Department of Primary Industries

OUT13/12644

Ravensworth Operations Project (PA 09_0176 Mod 1) Response to exhibition of Environmental Assessment

Ravensworth Operations Project (PA 09_176 Mod 1) **Response to exhibition of Environmental Assessment** **Additional comments by the NSW Office of Water**

Figure 14: 2D SEEP/W Cross Section Model Predictions

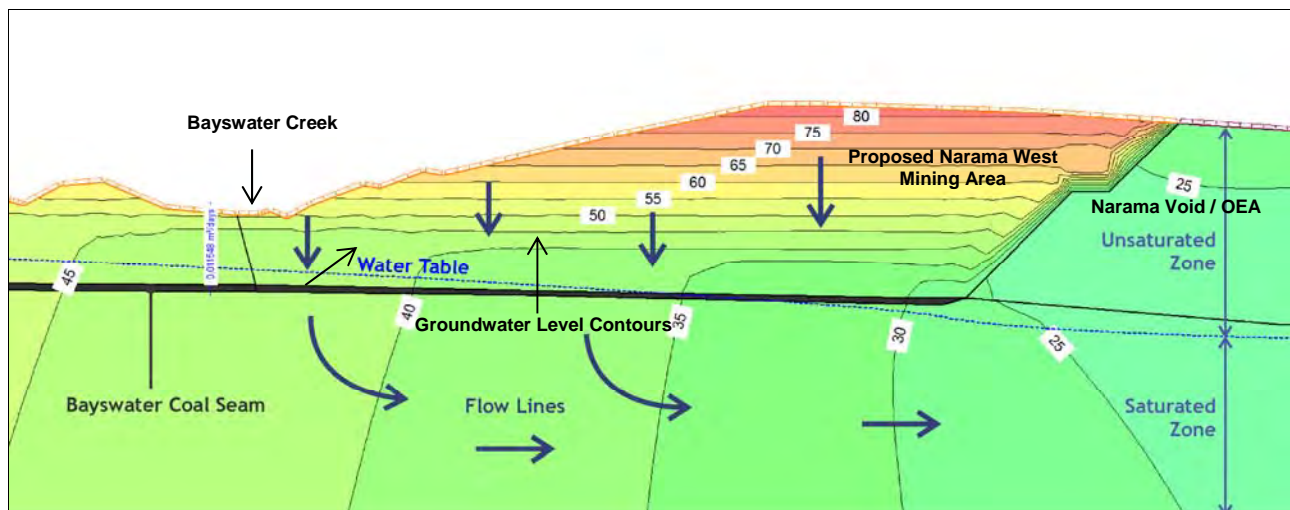
The proponent has used a steady state 2D SEEP/W to assess the impacts of the proposed modification. It is not identified why this approach was taken rather than using the existing numerical model developed for the Ravensworth Operations. It can only be assumed that there were limitations and the steady state 2D SEEP/W model would provide the most accurate prediction of the impacts of the modification.

The proponent has not classified the steady state 2D SEEP/W model to the Australian groundwater modelling guidelines. It is considered that this is a class 1 model.
